Ribble Valley Borough Council  
Housing & Development Control

Application no: **3/2023/1018**

Address: **Peele House Sawley Road Sawley BB7 4LE**

Proposal: **Proposed erection of a single-storey extension to rear; alterations to fenestration; addition of new door openings and internal re-modelling.**

6608 -P04E

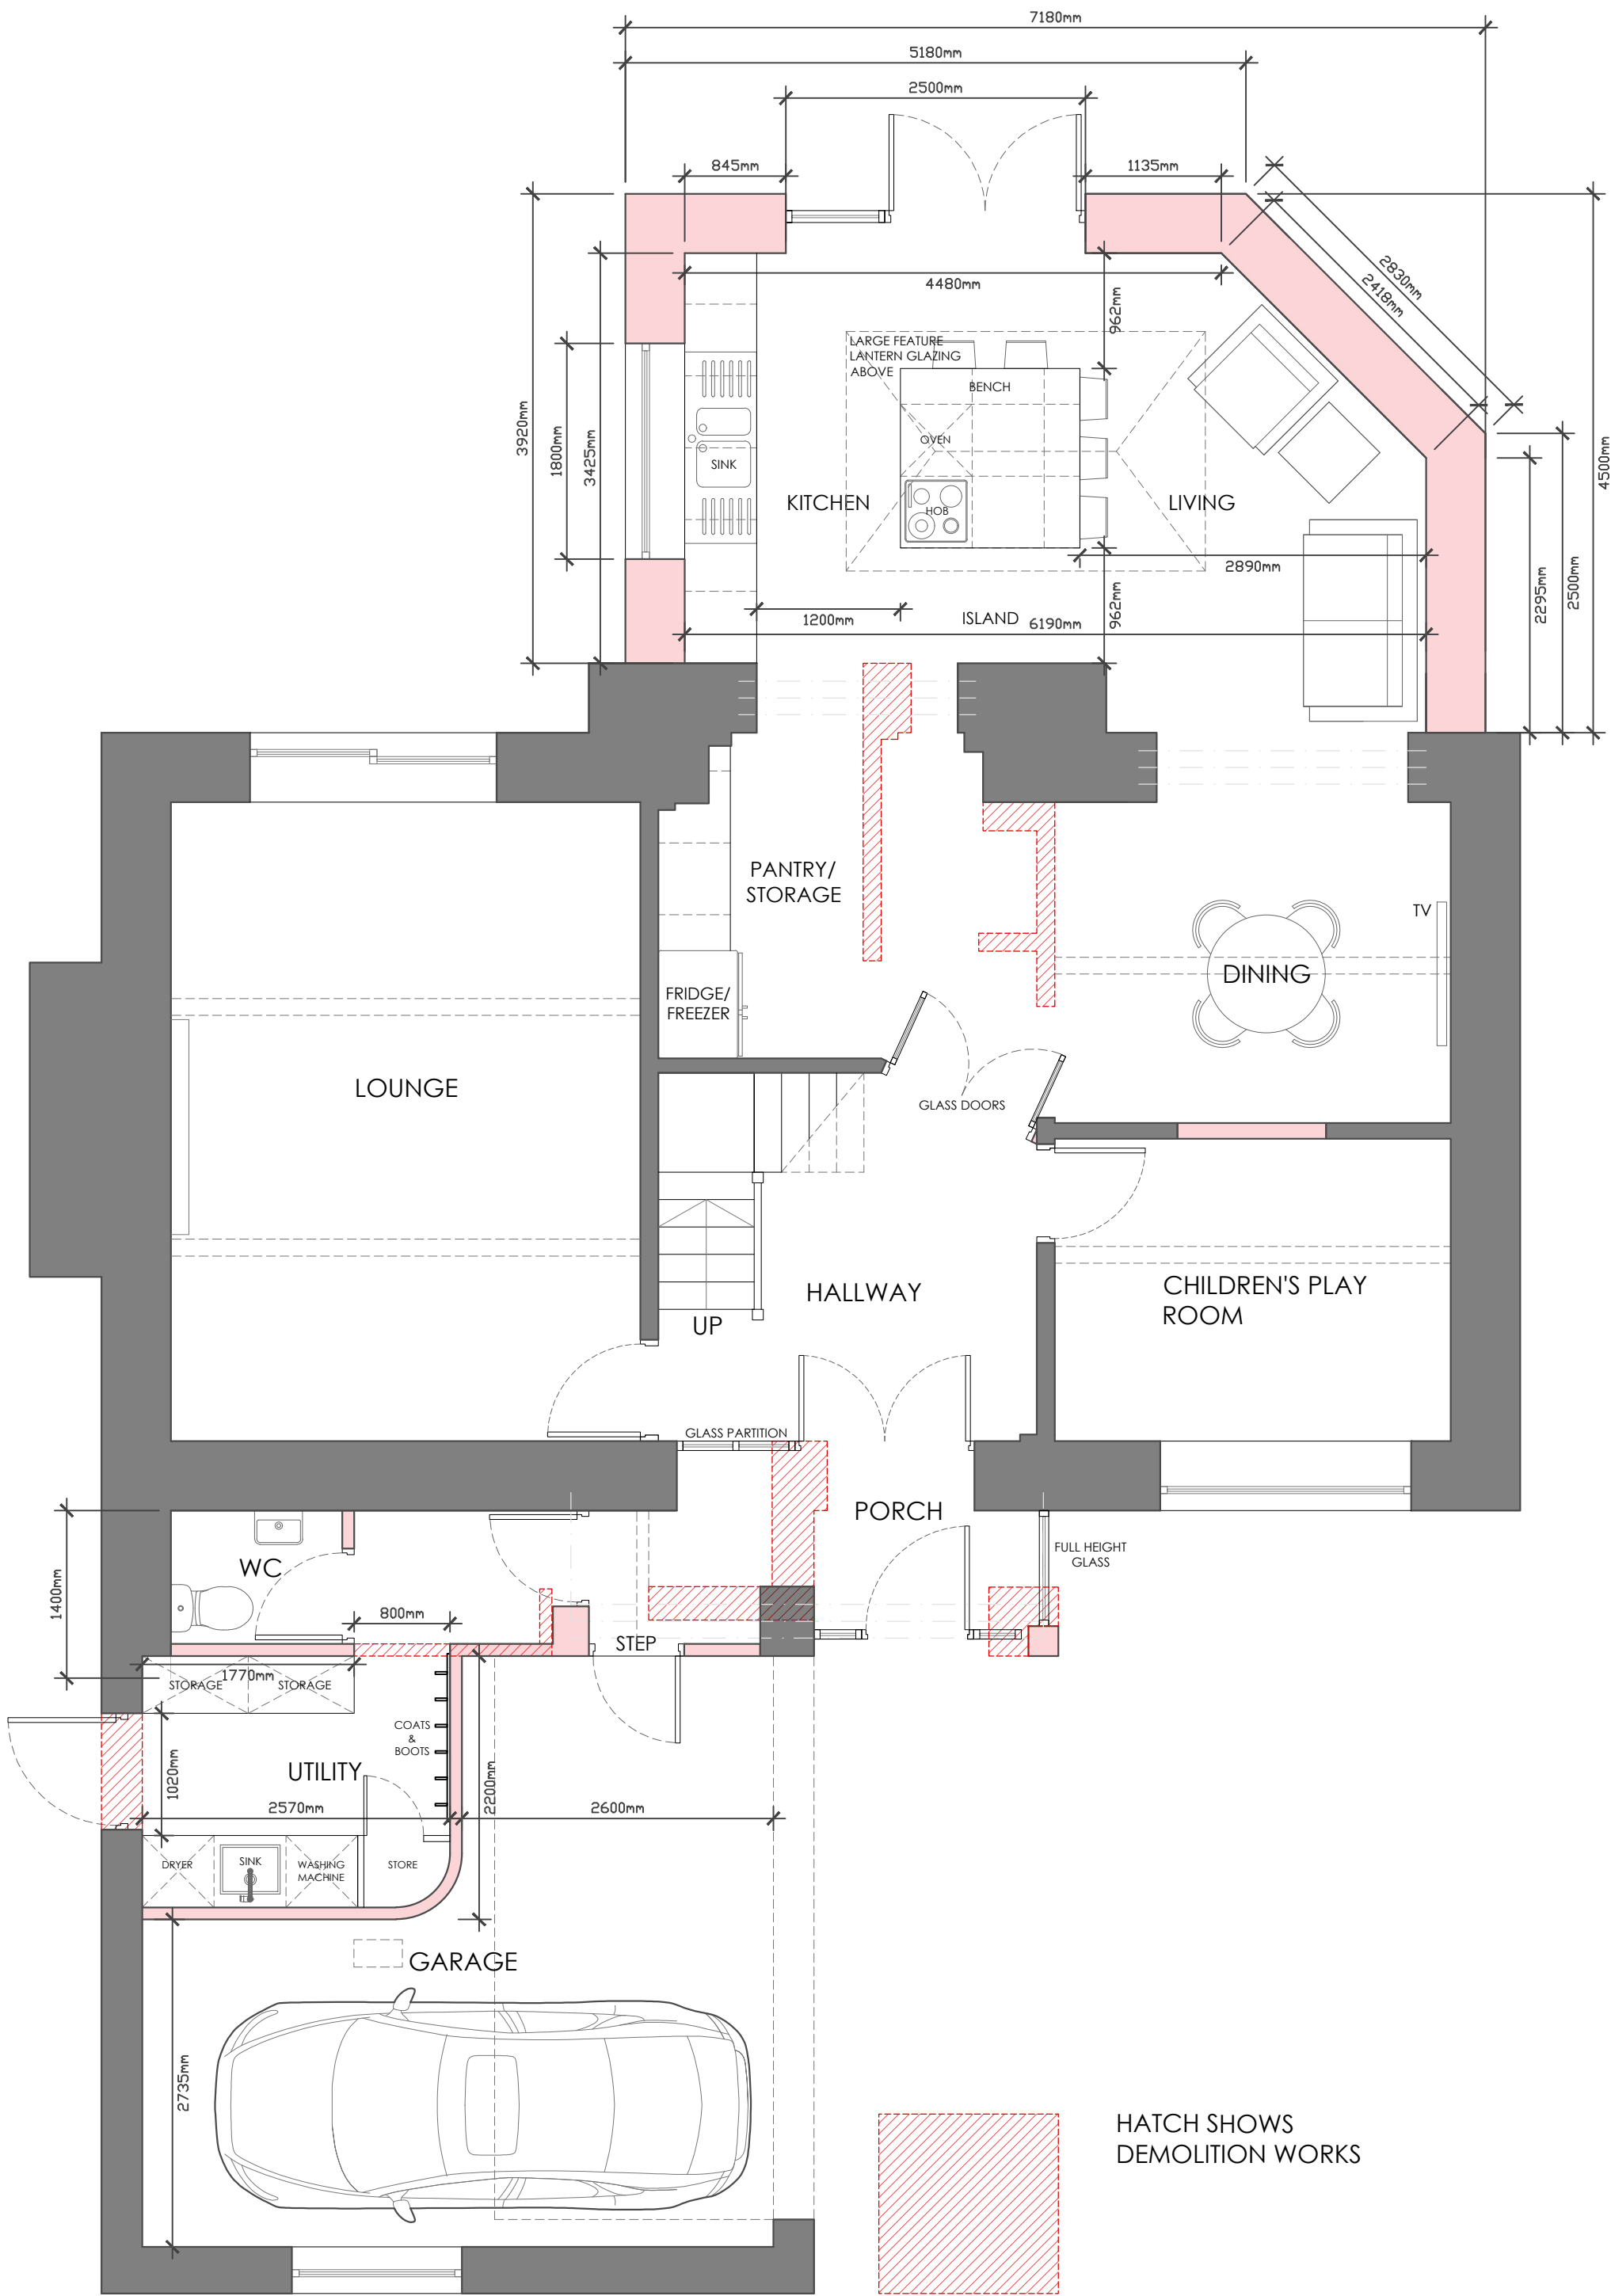
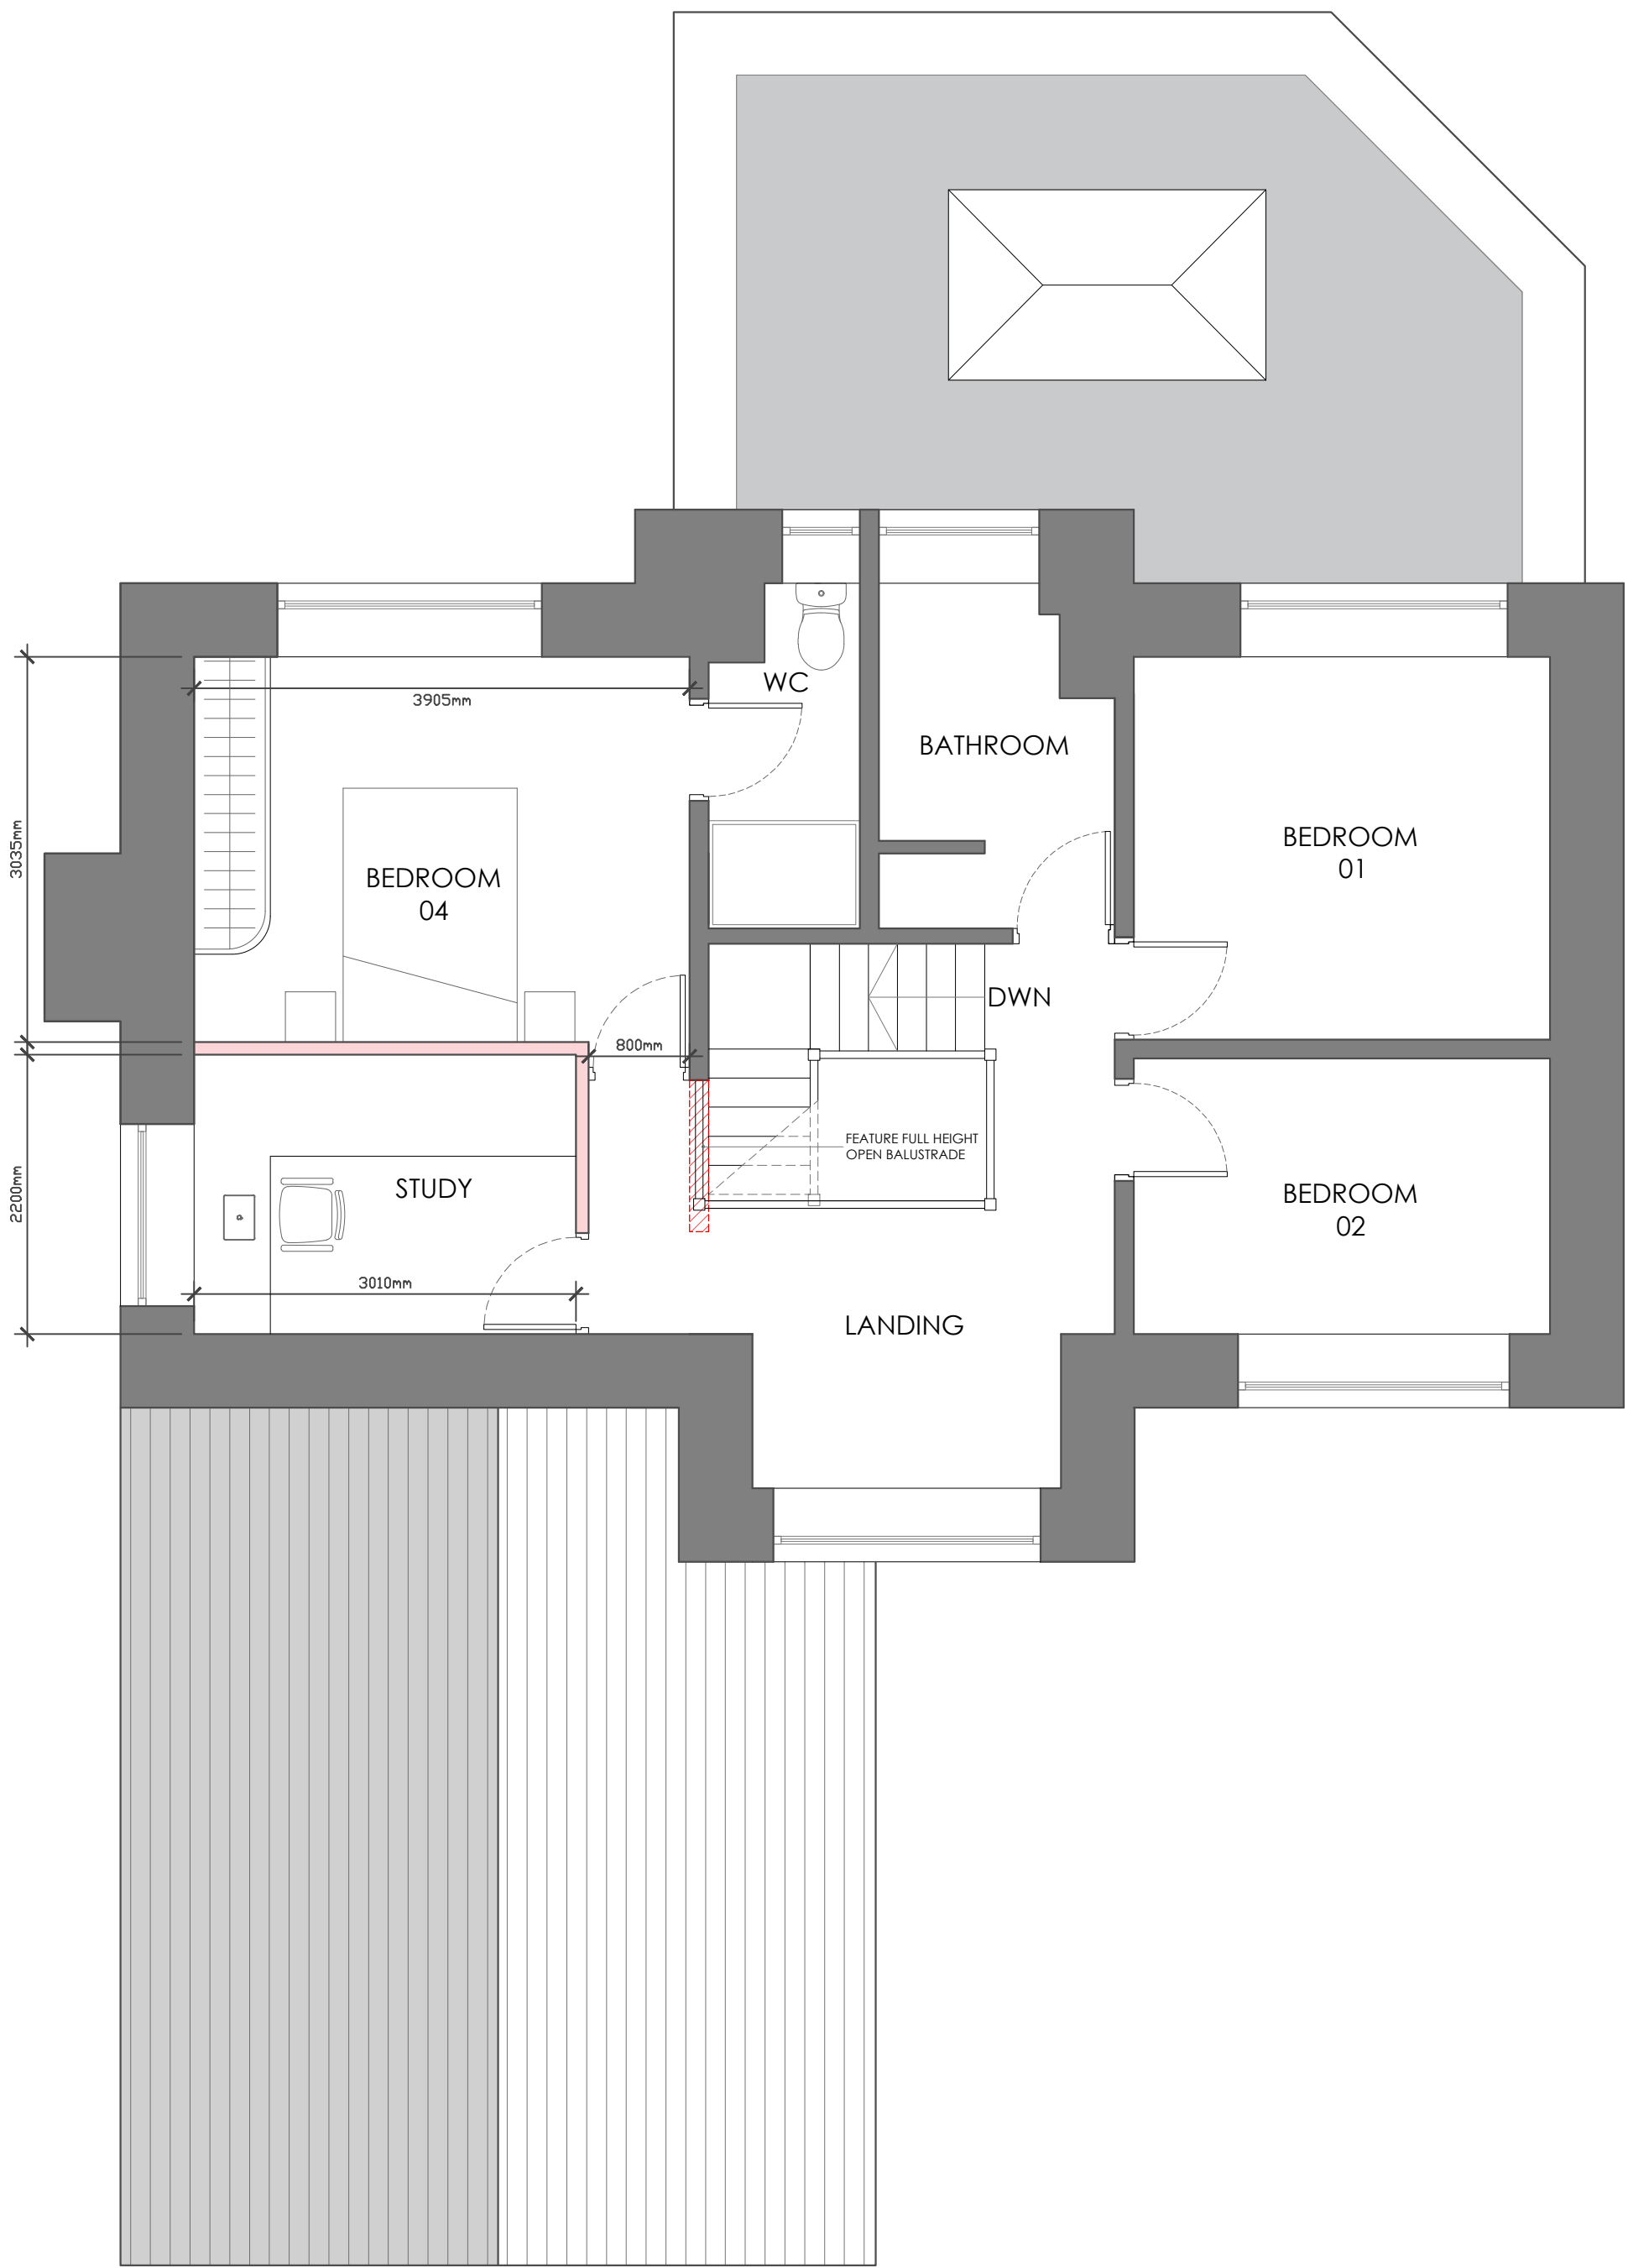
The LHA have reviewed the supporting documents and note that the number of bedrooms at the site will likely increase from 3 to 4. For the site to comply with the parking standards as defined within the Joint Lancashire Structure Plan, the LHA require 3 car parking spaces to be provided.

However, the site can only provide 2 car parking spaces with the integral garage as shown on SPA drawing number 6608-P04E titled "Single storey rear extension and internal remodelling- Proposed Floor Plans and Elevations" not having the adequate internal dimensions to provide a car parking space. With the LHA requiring the garage to be a minimum of 6m x 3m.

Despite the shortfall in parking, the LHA have no objection to the proposal. This is because any shortfall in parking at the site is unlikely to lead to any inappropriate parking on the adopted highway, with the dwelling being located on an unadopted track, approximately 49m from Sawley Road. Therefore, should the occupants require more than two car parking spaces they are likely to park on the unadopted track, a significant distance away from the adopted highway. As a result, the proposal is unlikely to have a material impact upon highway safety and so the LHA have no objection to the proposal.
